**WELWYN HATFIELD BOROUGH COUNCIL  
EXECUTIVE DIRECTOR - PLANNING, PUBLIC PROTECTION AND GOVERNANCE**

**DELEGATED APPLICATION**

**Application No:** 6/2019/0396/HOUSE  
**Location:** 107 Eddington Crescent Welwyn Garden City AL7 4SX  
**Proposal:** Erection of single storey front extension to facilitate conversion of garage, part two storey rear extension following demolition of conservatory, alterations to openings  
**Officer:** Ms Louise Sahlke

SIDE ELEVATION

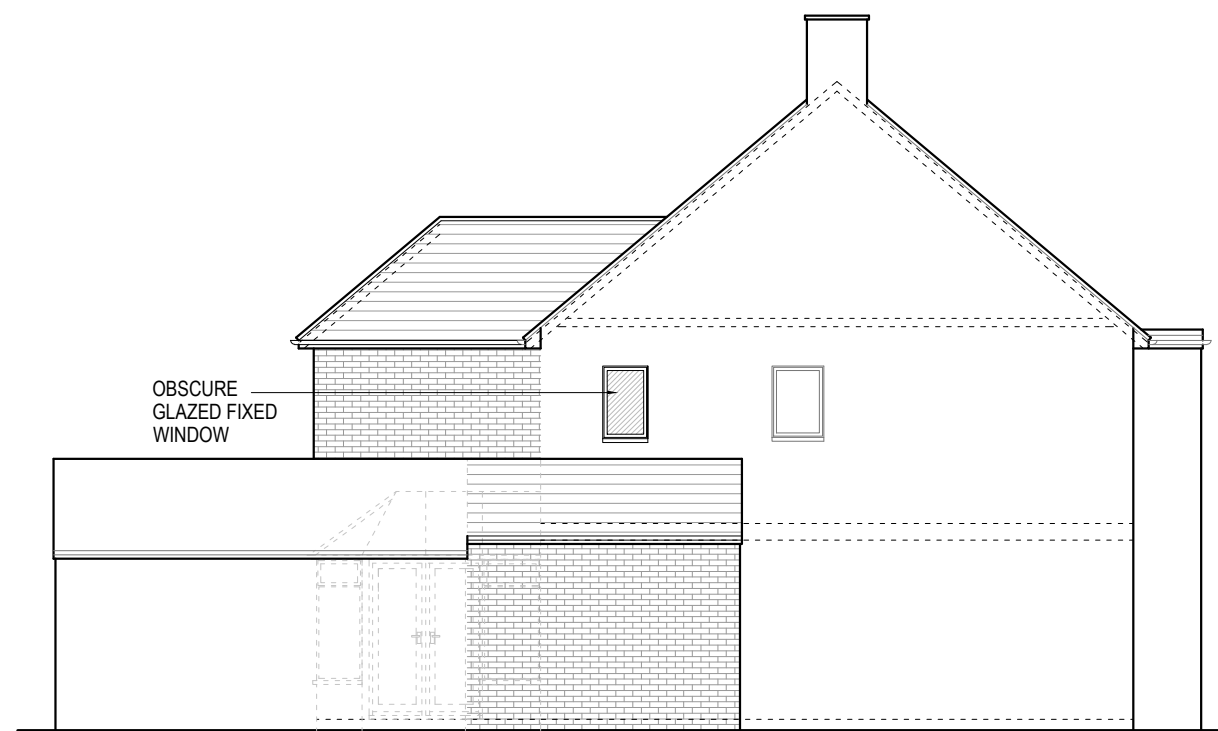
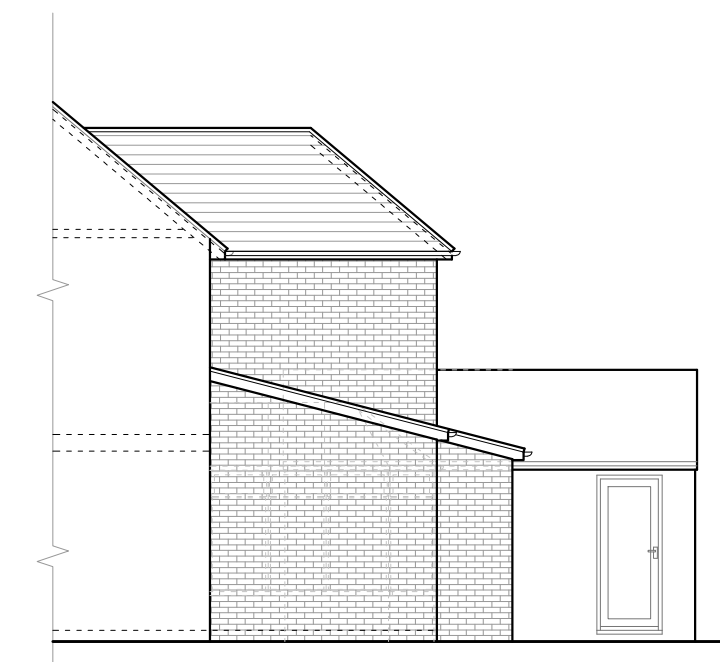
<p><b>Impact on neighbours</b></p>	<p><i>Loss of privacy</i></p> <p>The impact on neighbouring properties has been removed from the previous planning application due to the rearrangement of the internal layout which has changed the room from a habitable room requiring a clear glazed and openable window to a non-habitable room which could be obscurely glazed and non-opening.</p> <p>An assessment has been undertaken of the proposed first floor flank window which serves the ensuite. This window is annotated as obscure glazed and</p>

fixed. Therefore would result in satisfactory living conditions for neighbouring properties.

3. The proposed upper floor window located in a wall forming a side elevation of the building hereby approved must be obscure-glazed and non-opening unless the parts of the window which can be opened are more than 1.7 metres above the floor of the room in which the window is installed, and shall be retained in that form thereafter.

GROUND FLOOR PLAN

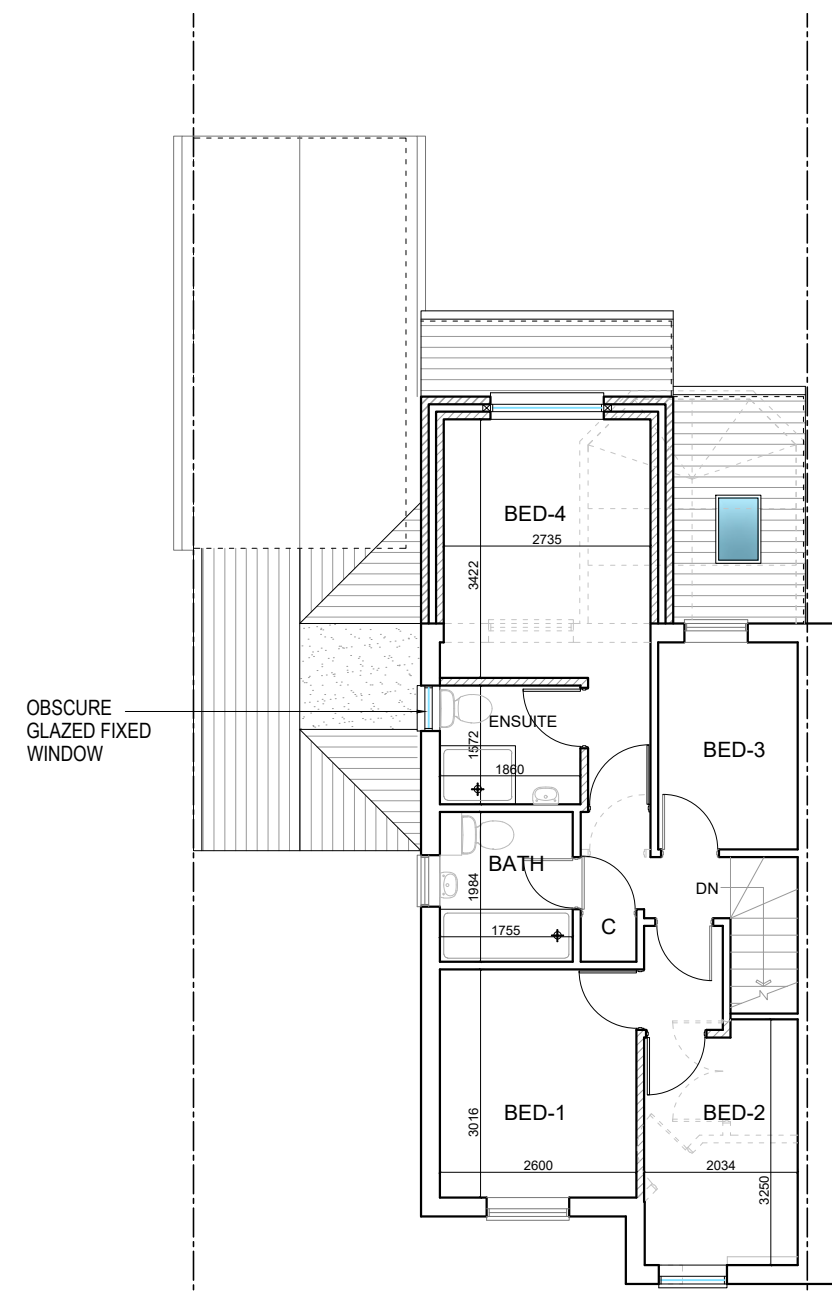
The proposed ground floor window and doors would be located behind the existing built form of the garage and within the existing garage and face down the rear garden therefore would not result in any additional loss of privacy or overlooking to neighbouring properties. Therefore are considered acceptable.
